# CITY OF ALBUQUERQUE

May 7, 2019

**Re: Academy parkway Self Storage**  
**6801 Academy Parkway NE 87109**  
**Traffic Circulation Layout**  
Engineer's/Architect's Stamp 05-01-19 (E17D001W)

AS-1.0

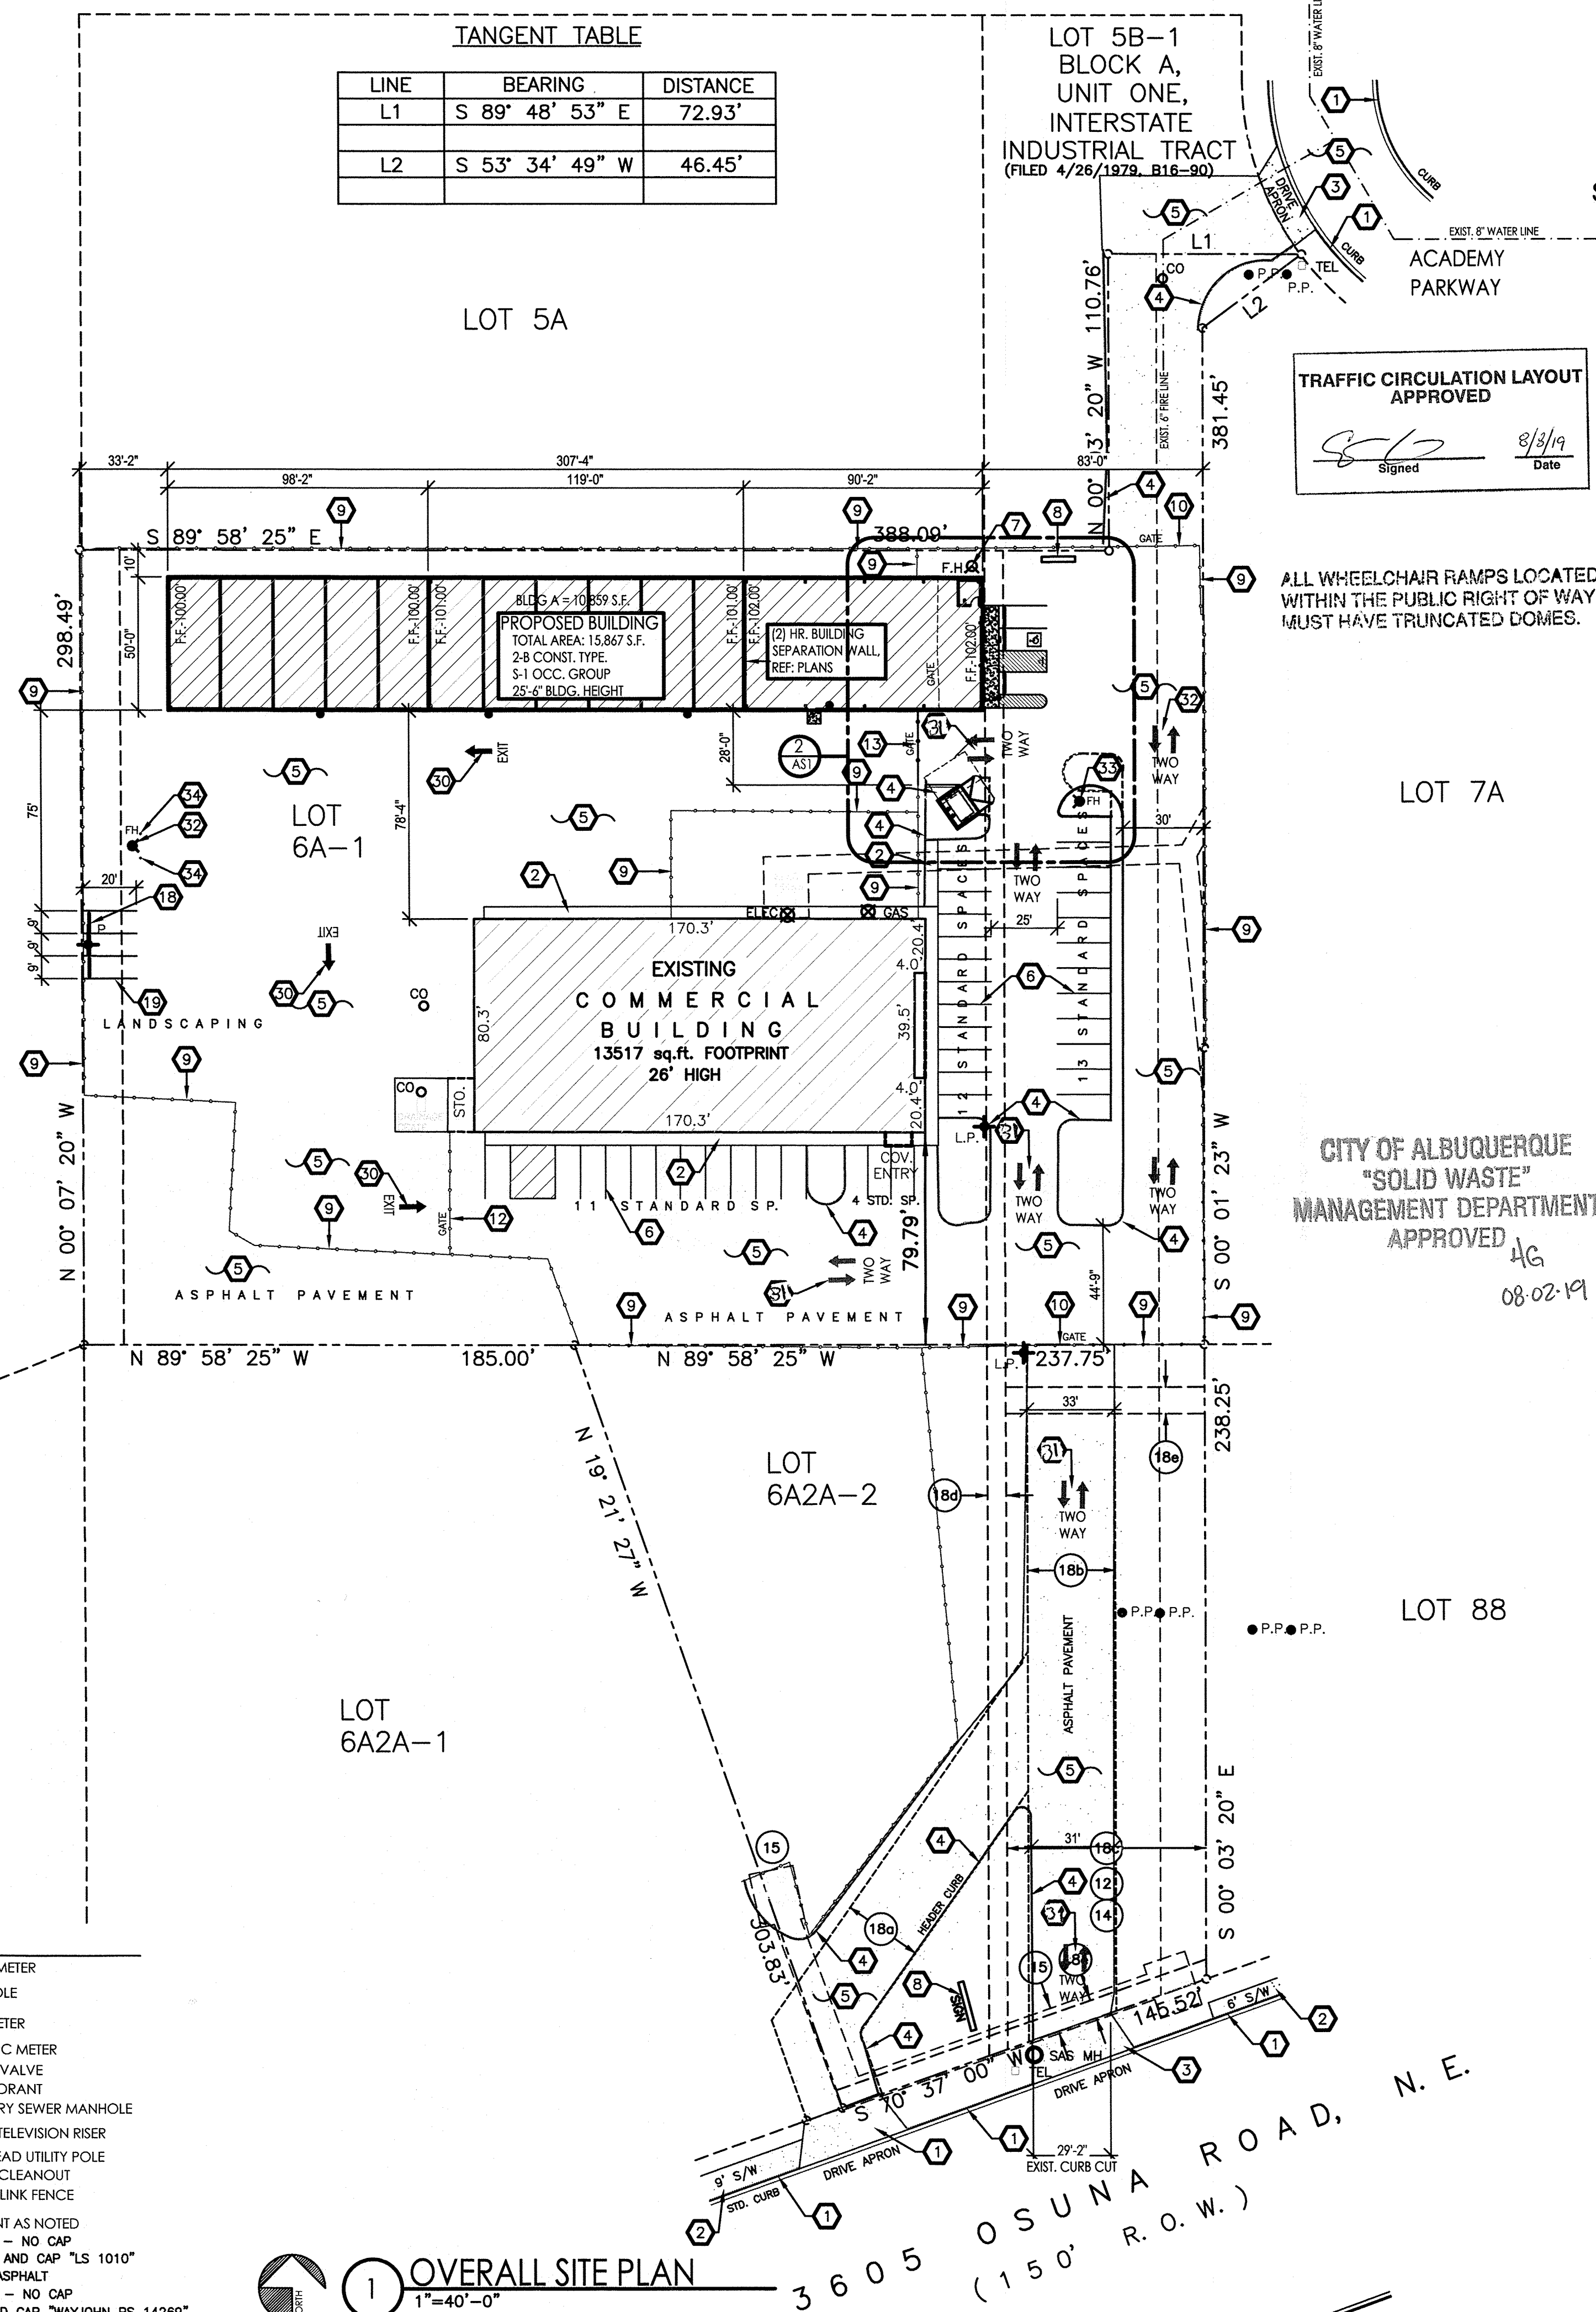
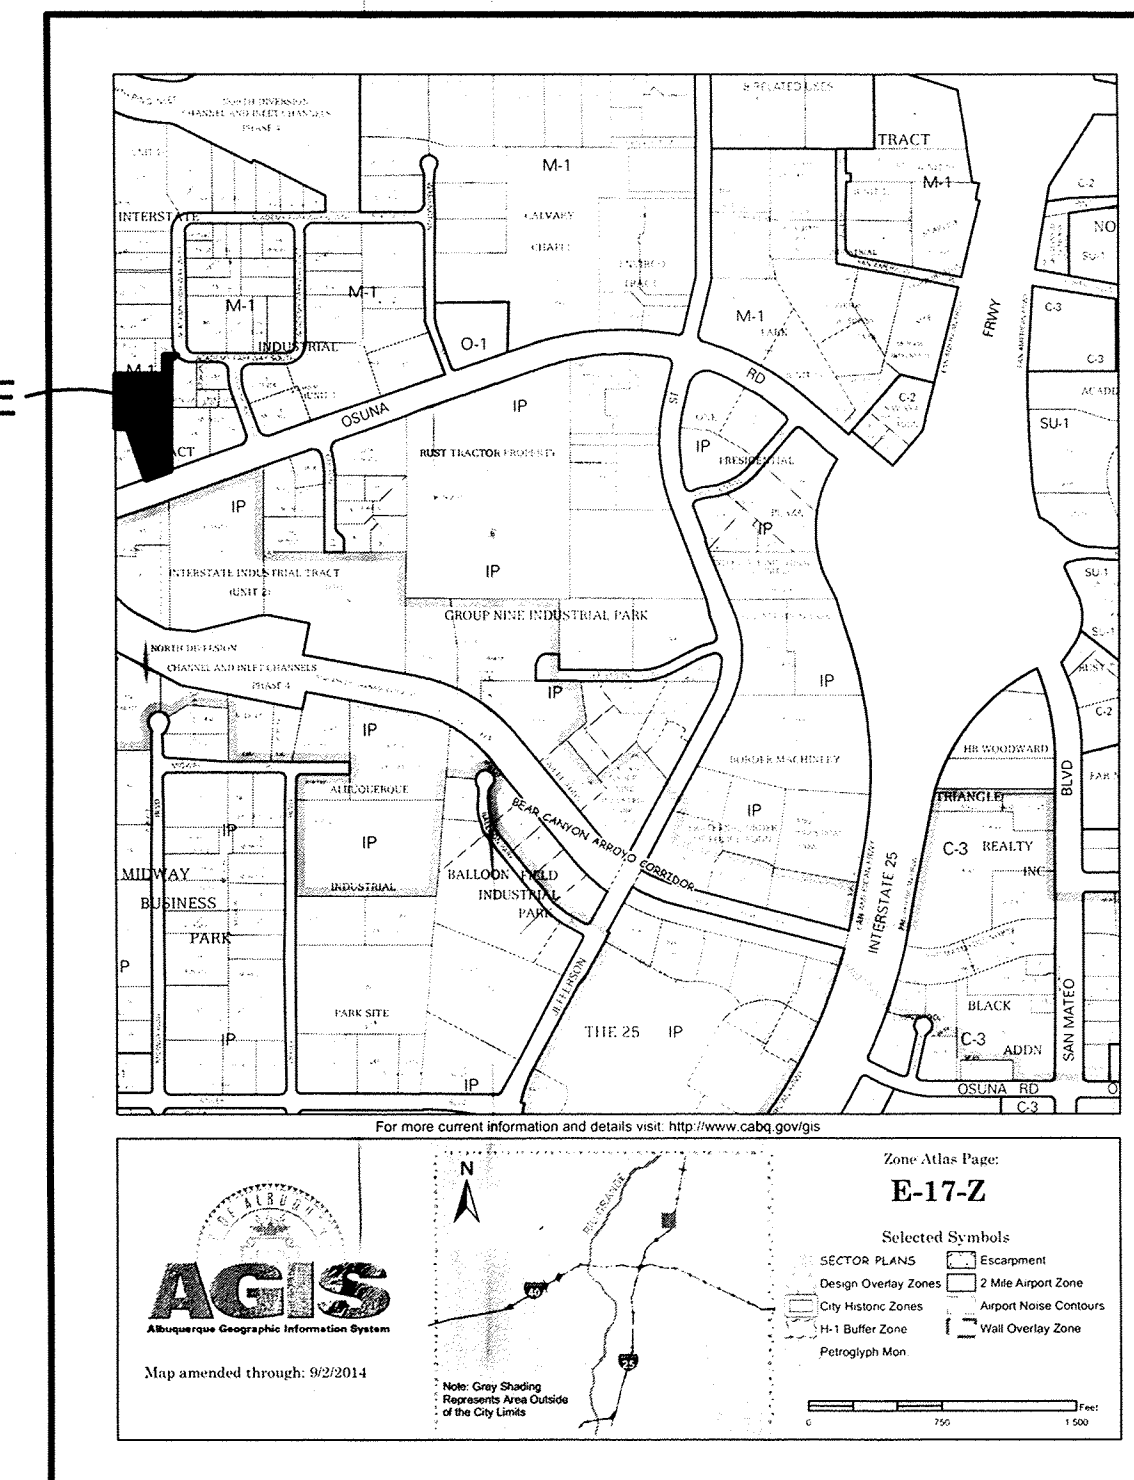
1. The ADA accessible parking sign must have the required language per 66-7-352.4C NMSA 1978 **"Violators Are Subject to a Fine and/or Towing."** Please call out detail and location of HC signs.
2. provide a copy of refuse approval.
3. Please provide an access easement for the access off of Academy Parway.
4. The address " 6801 Academy Parkway NE " does not exist on AGIS map. Please contact Jeanine Vivian, our senior planning assistant.
